Recommendation Report for Planning Permission for Works or Extension to a Dwelling

REF NO: BN/152/21/HH

LOCATION: 3 Abercorn Walk
Old Rectory Drive
Eastergate
PO20 3XE

PROPOSAL: Erection of single storey front extension to attached garage.

Stage	Planning
Project	Abercorn Walk
Client	Open Design Studio
Drawing No.	2129-OPDS-00-101
Title	Proposed Roof Plan
Scale	1:100@A3
Drawn	FA

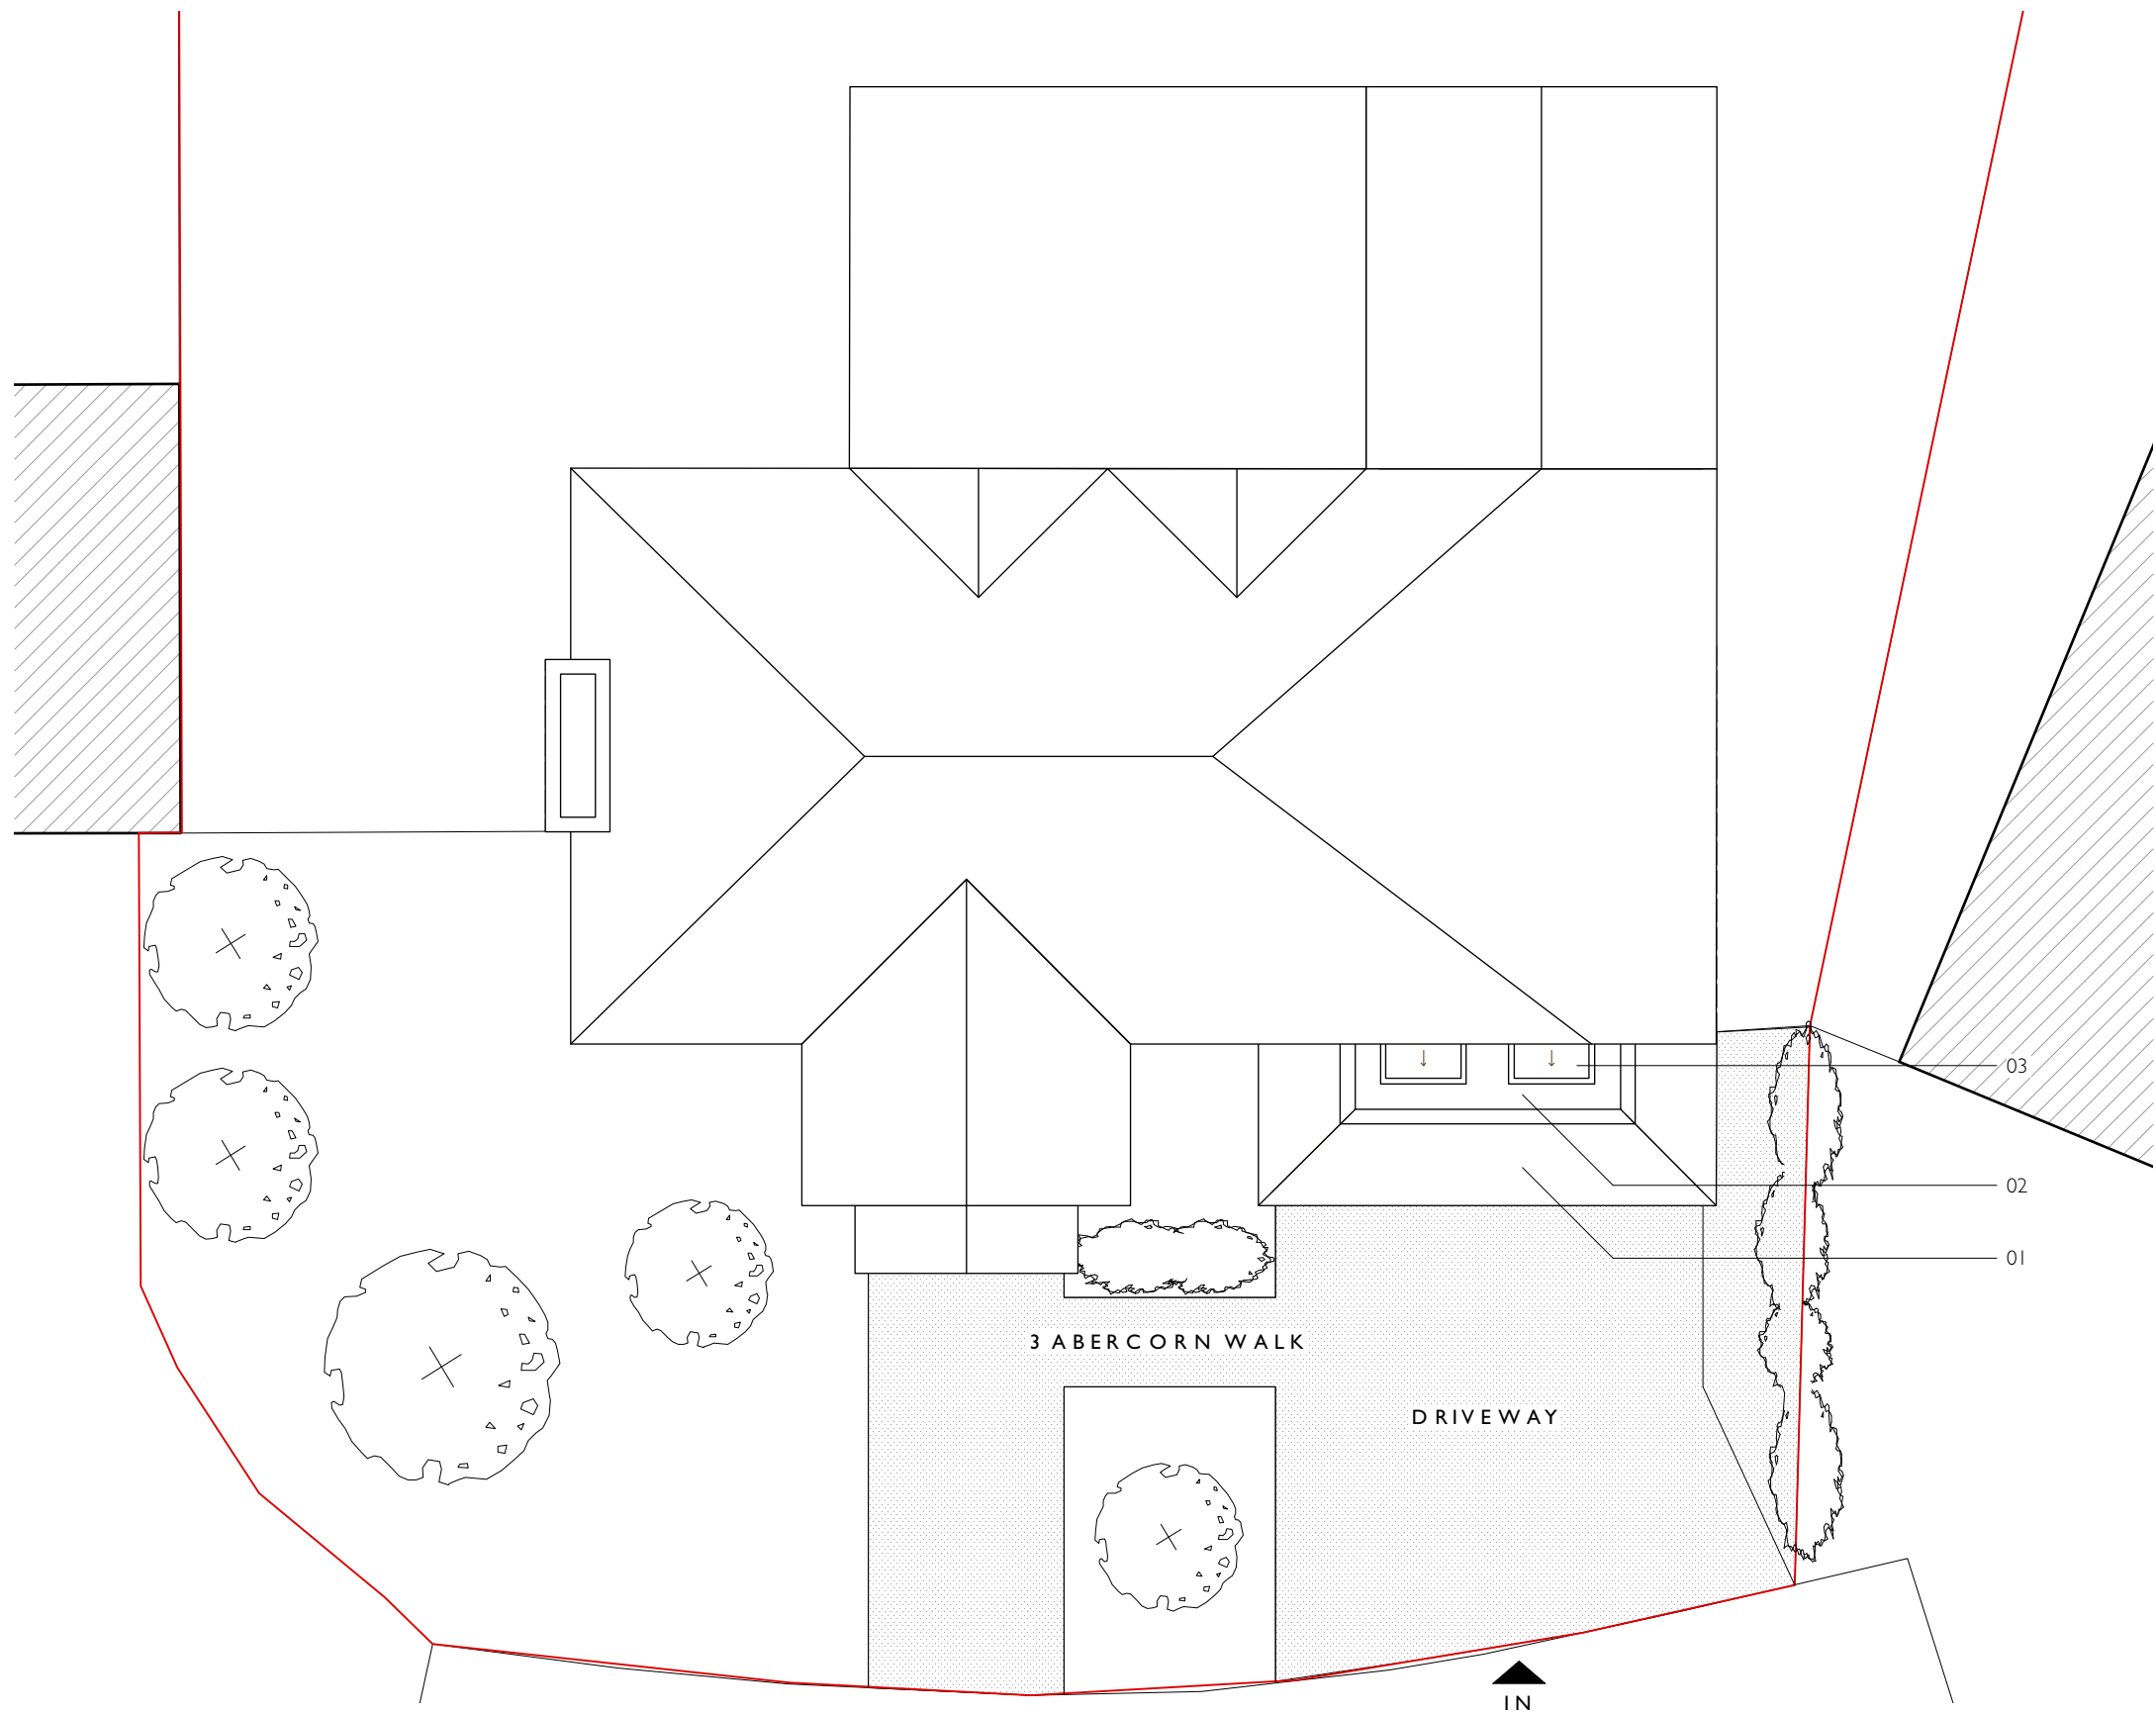
The garage features a new rolling garage door to the front and two skylights in centre of the flat roof. Given the use, scale and location of these features, they do not give rise to any overlooking, overbearing or overshadowing. They are not considered to be unduly harmful to the privacy of neighbouring properties and have no adverse impact upon residential amenity.

Stage	Planning
Project	Abercorn Walk
Client	Open Design Studio
Drawing No.	2129-OPDS-00-100
Title	Proposed GA Plan
Scale	1:100@A3
Drawn	FA

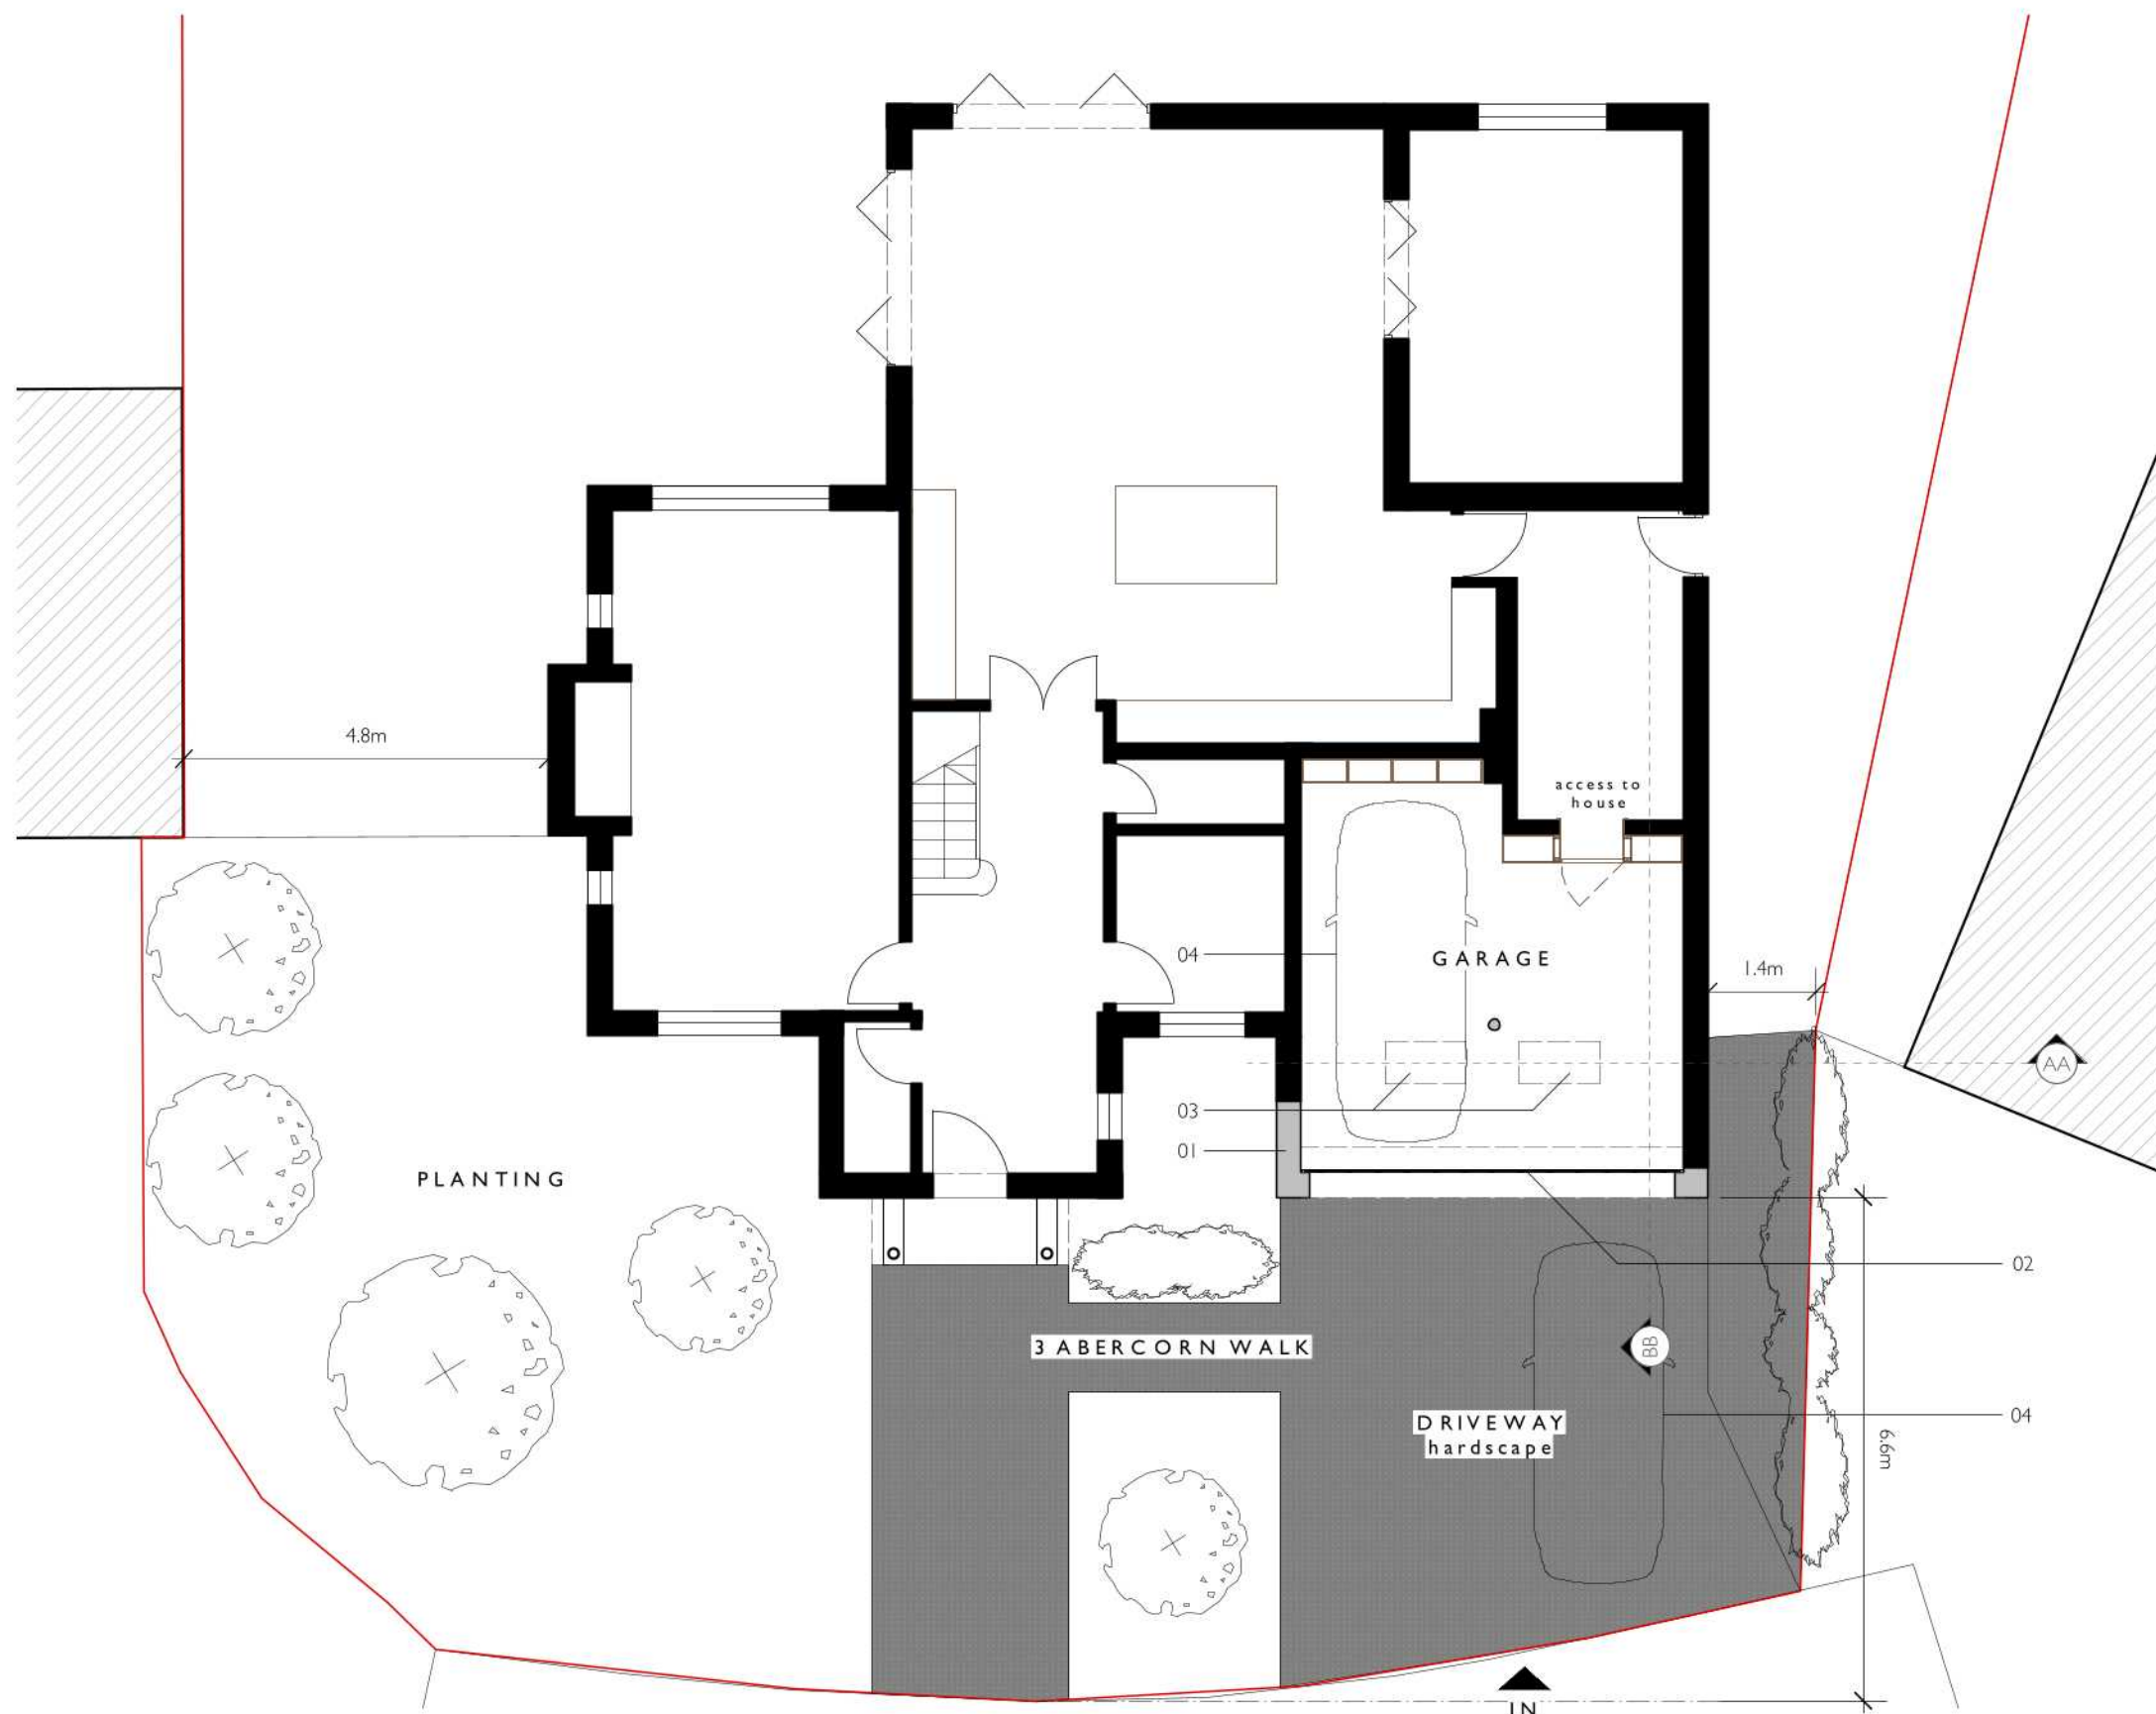
The extension will protrude the garage forward, but not past that of the existing porch and will retain the established building lines. Neighbouring properties are not located directly in line with the host dwelling and therefore will not be unacceptably impacted by the slight protrusion of the proposal.

The extension minimally reduces the size of the driveway but does not change the number of parking spaces available to the property. The proposal has no impact on Highways.

Stage	Planning	Rev	00
Project	Abercorn Walk	Description	First issue
Client	Open Design Studio	Issue Date	11.21
Drawing No.	2129-OPDS-00-200		
Title	Proposed Elevations		
Scale	1:100@A3		
Drawn	FA

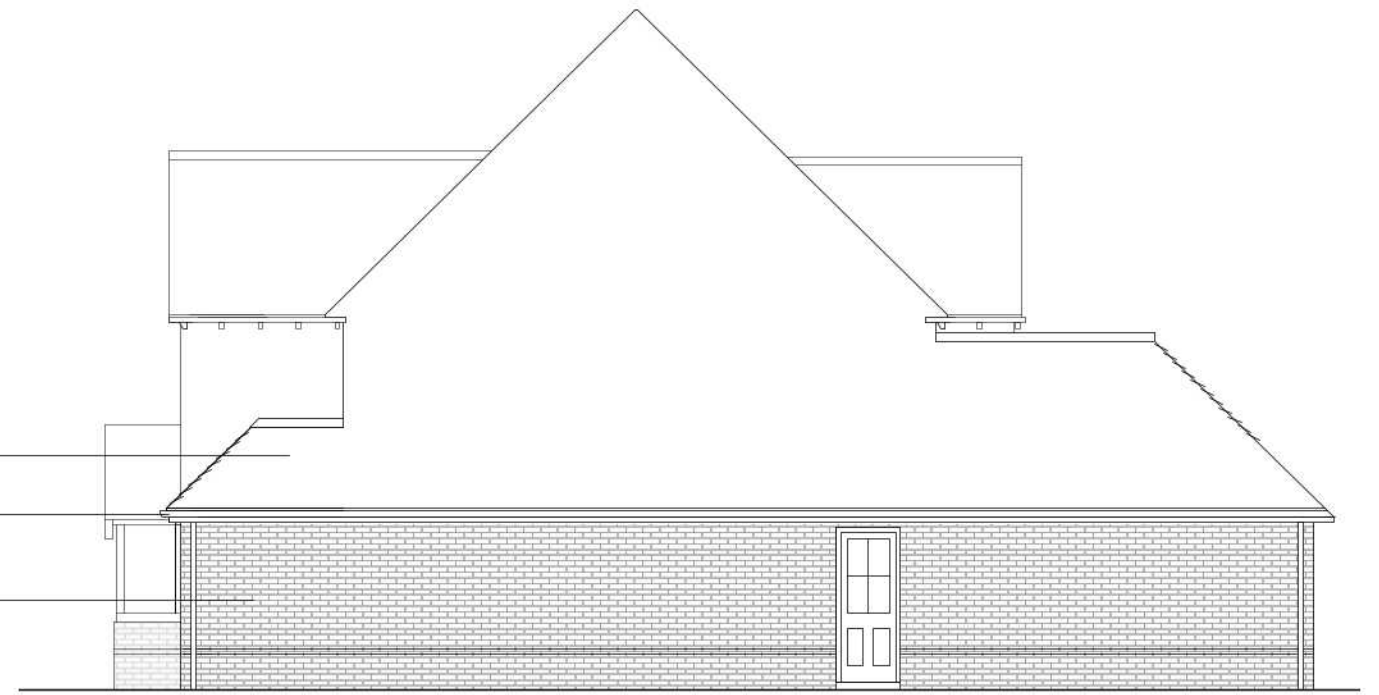
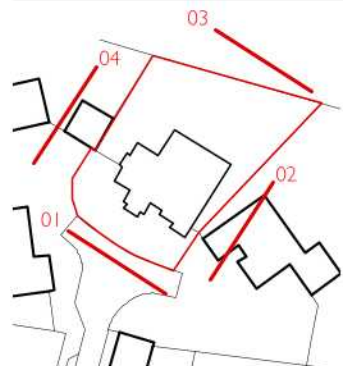
The garage has a stepped design, with two parking spaces inside. The proposal will extend the garage forward to be in line with the existing front porch, making the footprint of the garage square. It will have a maximum depth of 1.3m and retain the existing width of 5.75m. At present, the garage has two pitched roofs, one being a gable, the other being pitched with a flat roof. The extension will have a pitched to flat roof, matching the design and angle of the existing garage, and following a similar style and pitch to the main roof. As a result, it is has minimal imposition on the buildings visual appearance and is sympathetic to the existing. The garage retains 6.7m from the front boundary and is clearly visible from the street scene. Abercorn Walk is a small private close comprised of four detached properties, all exhibiting variations of a similar design style. The extension is in keeping and follows similar design aspects to its surroundings, and will not be unduly harmful on the character of the area. Although being clearly visible from the close, it is not visually intrusive and has no adverse impact upon the composition or rhythm of the street.

The extension appears subservient to the host dwelling and is well integrated. The materials used will match that of the existing. The garage will feature a new up-and-over roller single garage door, which will be painted to match the existing woodwork of the host dwelling. This will ensure minimal visual intrusion.

The extension will be to the front of the property. It will be single storey with a pitched and flat roof, at a height of 3.6m at the top, and 2.4m at the eaves. The height and size of the extension is not considered to be unacceptably overbearing and will not give rise to adverse overshadowing of neighbouring properties. It retains 1.4m from the neighbouring side boundary and is in accord with D DM4 of the Arun Local Plan.
